## REVISION/DEFERRED SUBMITTAL FORM

Site Address 8455 SE 83rd Street

Permit Number 2208-260-SUB-1

Date March 31, 2023  
To City of Mercer Island  
Community Planning & Development  
From Chris Haddad  
Permit Number **2208-260-SUB-1**  
Project Address 8455 SE 38rd Street  
Mercer Island, WA 98040  
Reference **Jaffe Residence - Revisions to a plan currently in review**

**A2.1**

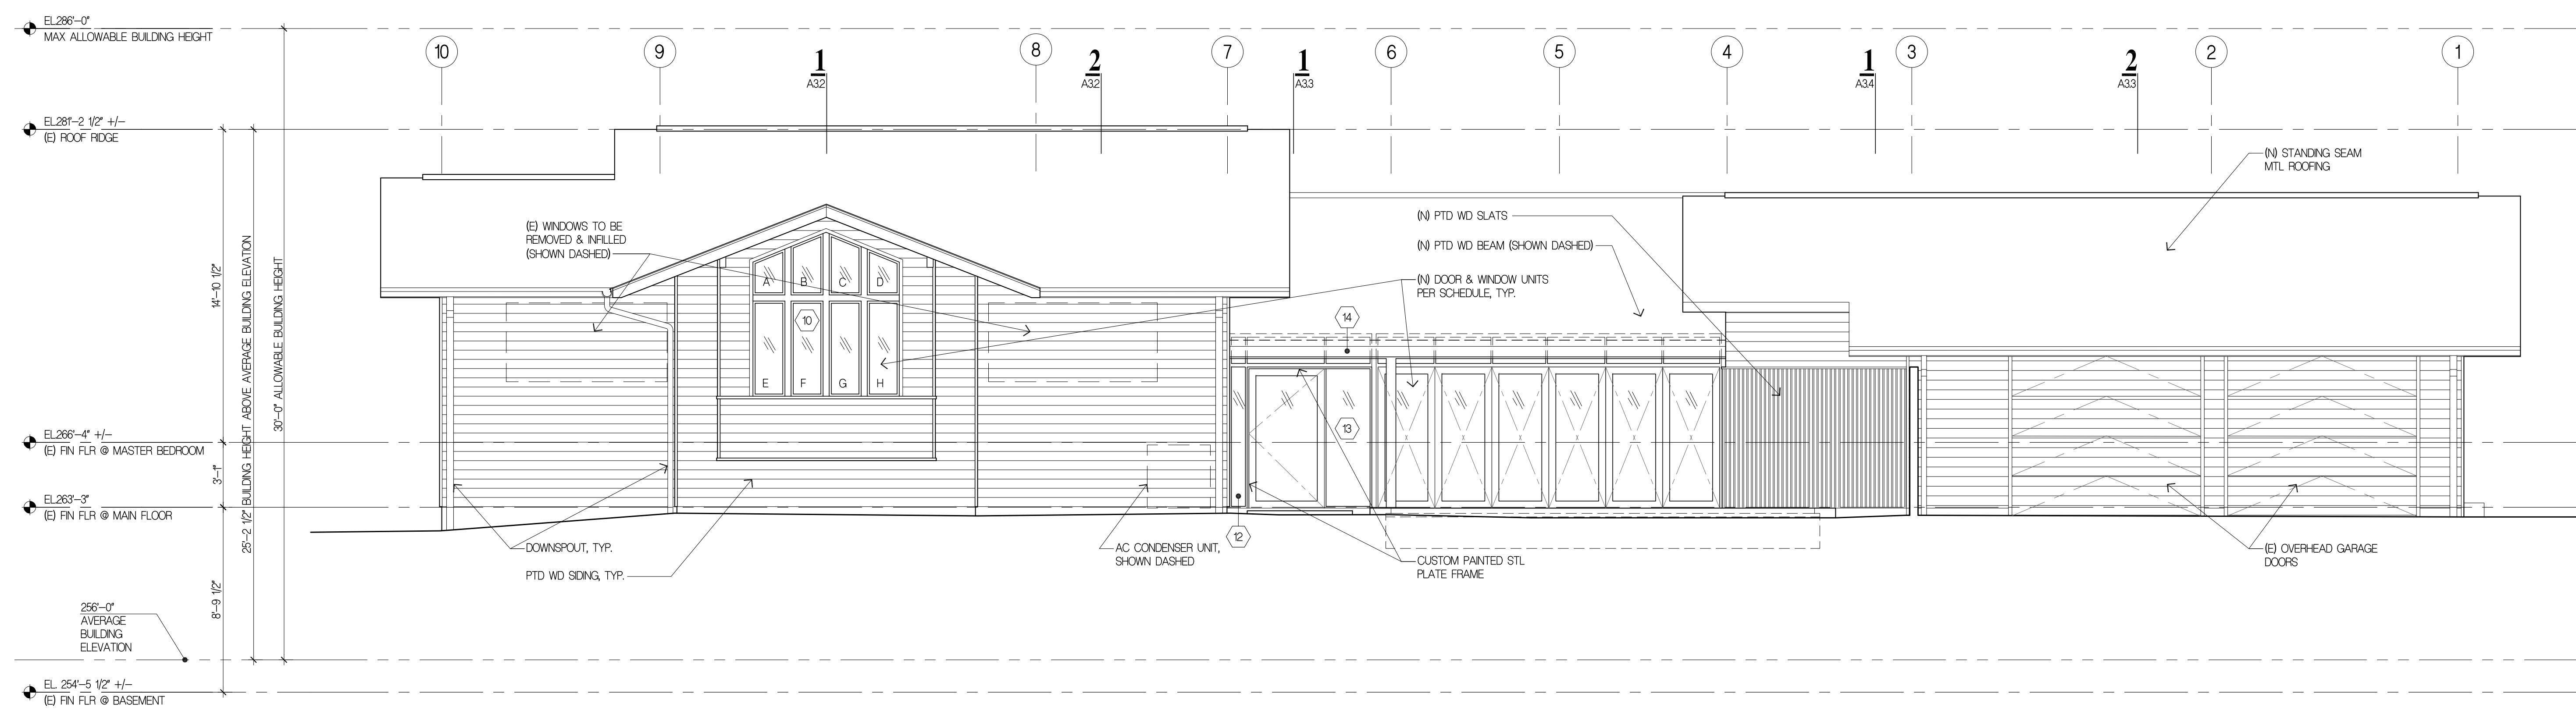
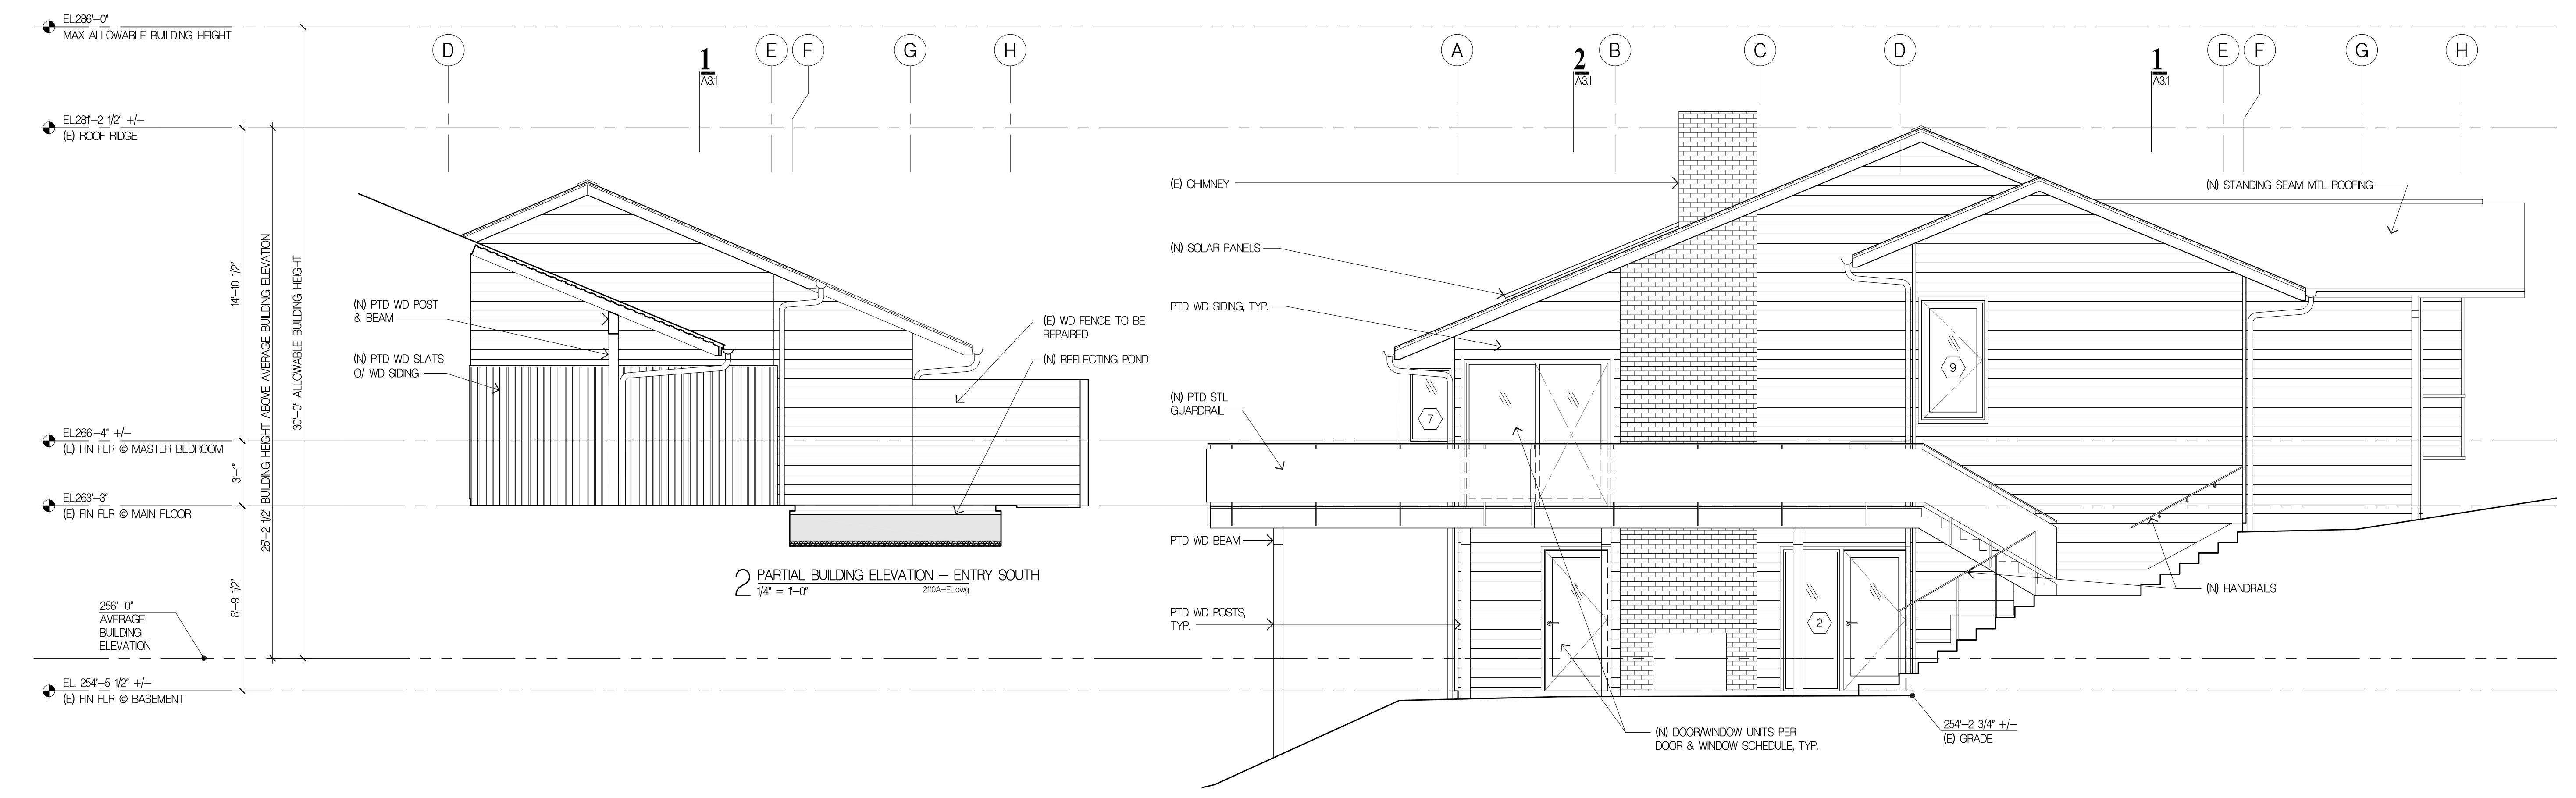
- The Elevations and Sections have been revised to reflect the revised floor plans.
- A few windows and doors have been revised to save the (E) openings as much as possible. Refer to the Window & Door Schedule on Sheet A3.4.

**TS-1**

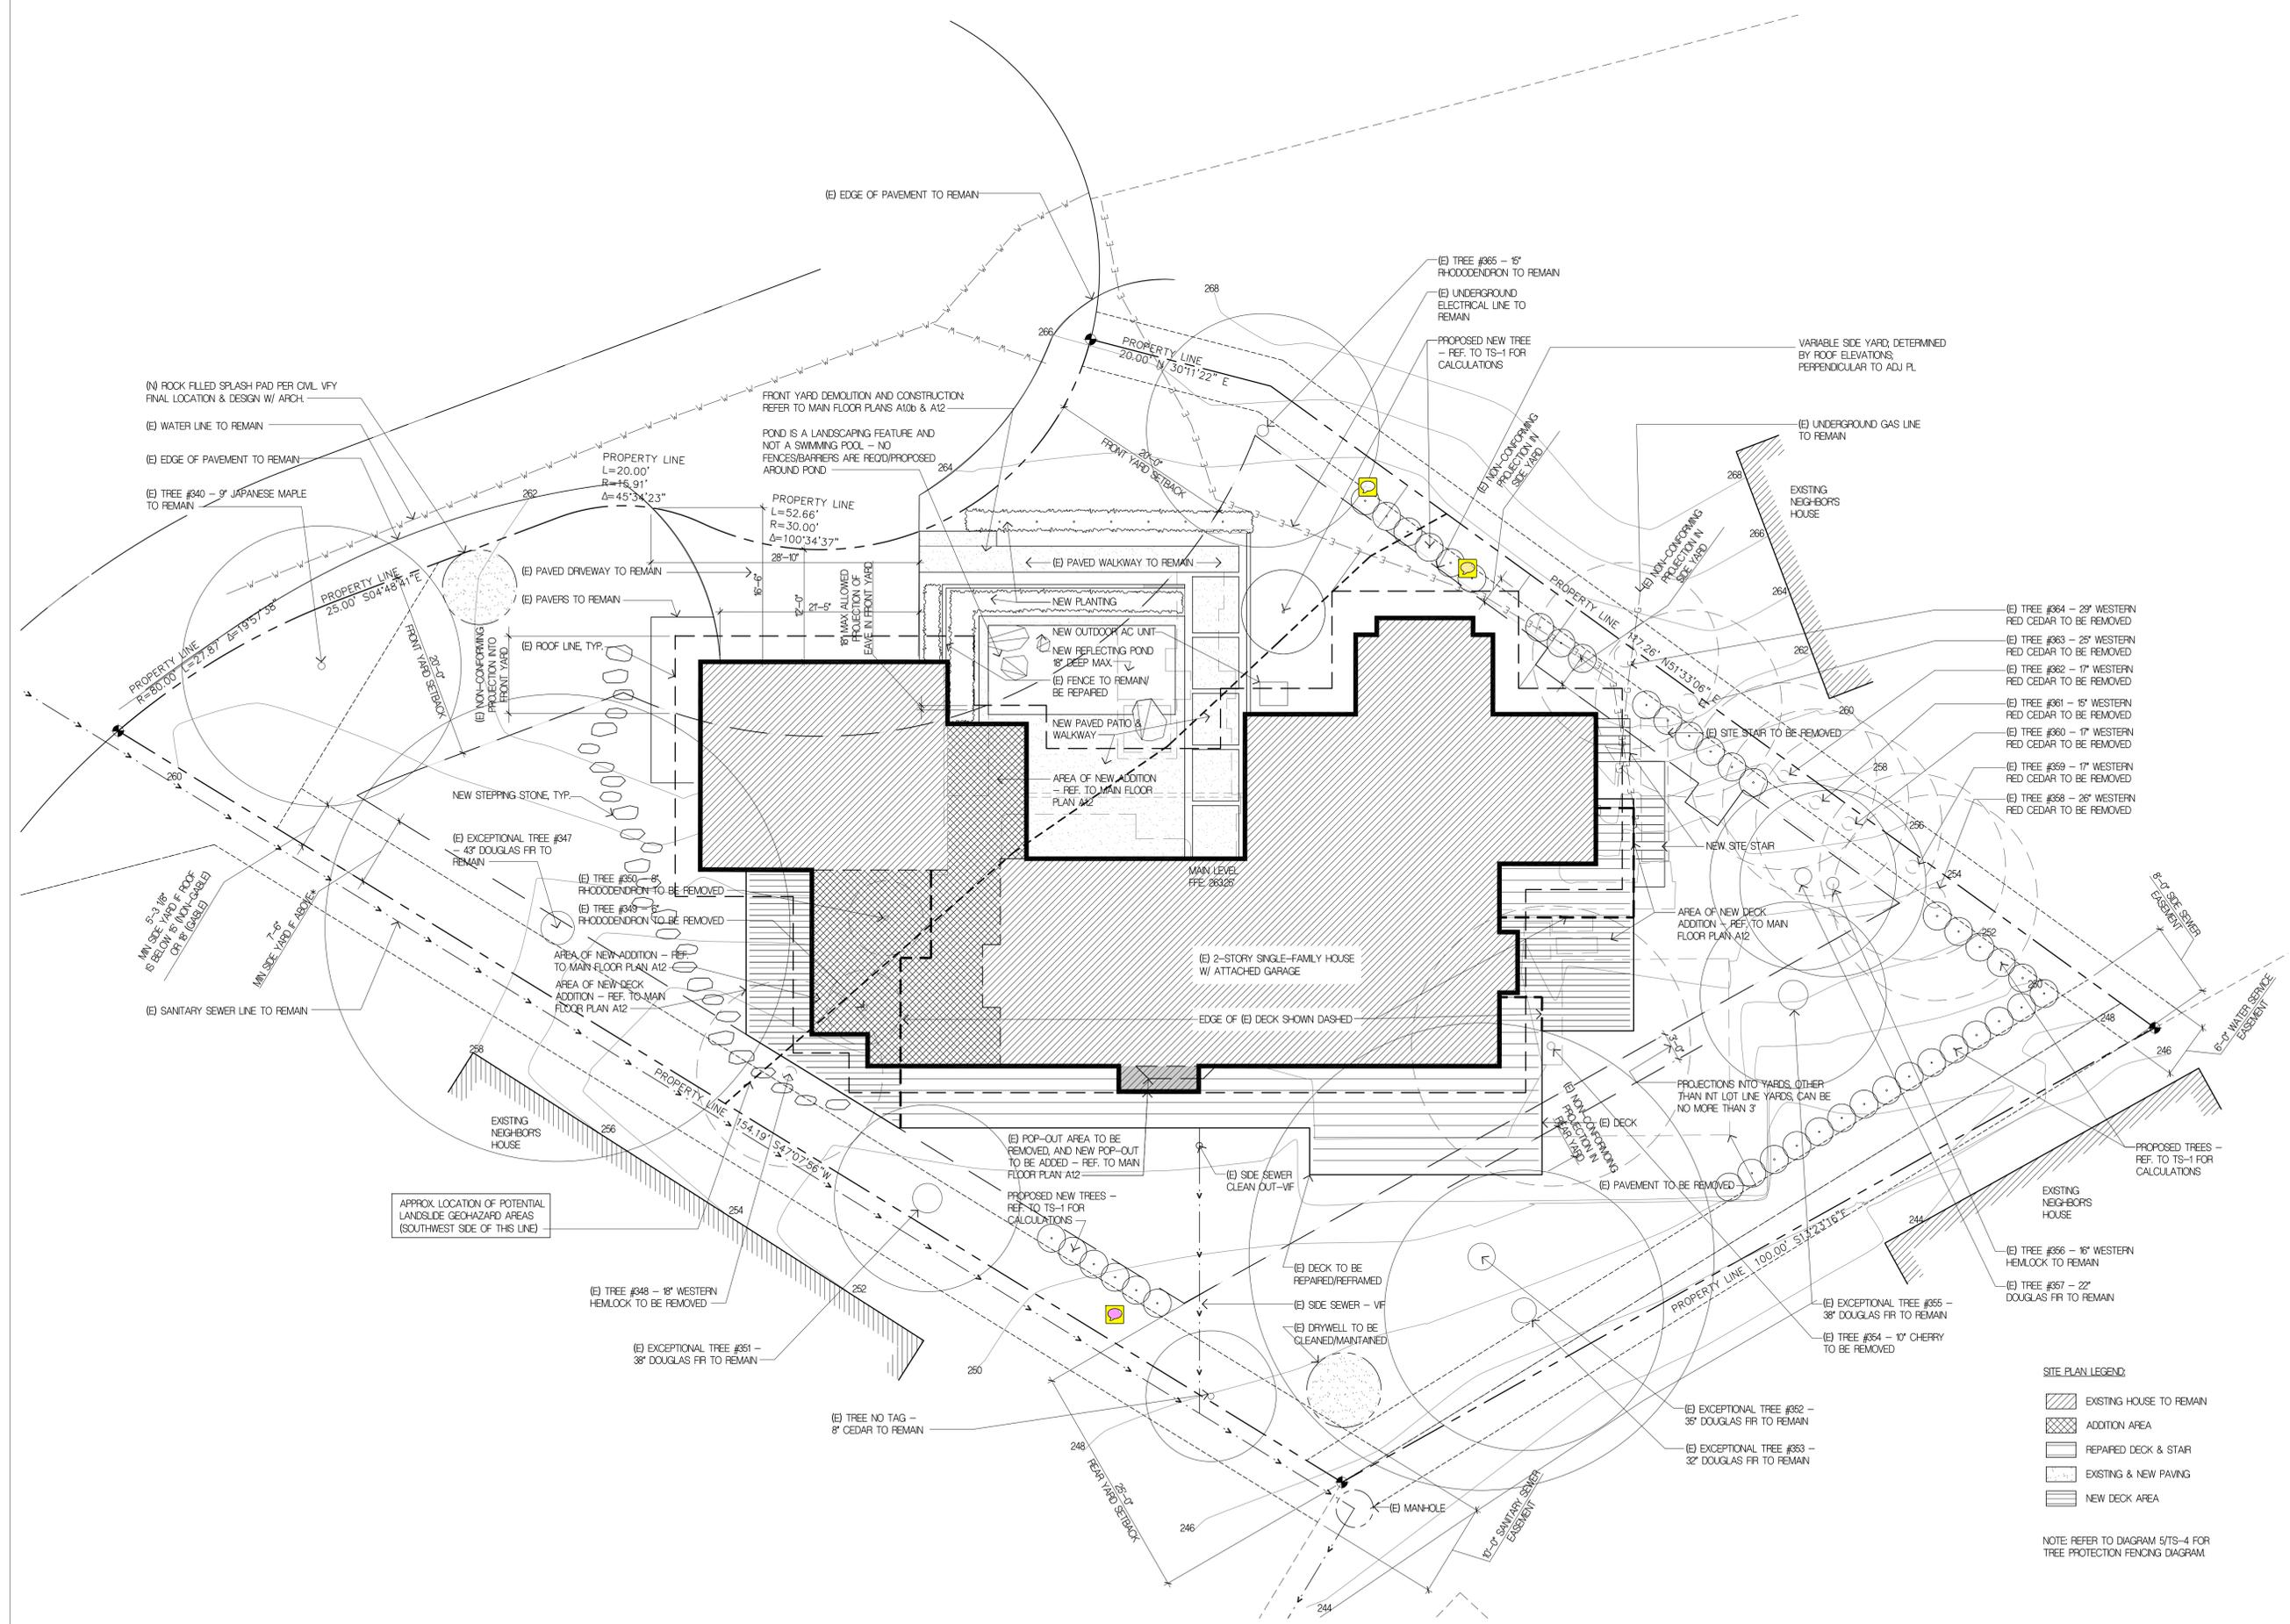
- Energy Code Notes have been revised to show an alternative approach to achieve the required energy credits.

- Water Service Notes and Fire Protection Notes have been revised to show that we are no longer proposing a new fire-sprinkler system as the estimated construction cost is less than 50% of the current house value.
- Zoning Information Notes have been revised to reflect smaller area of the proposed addition.
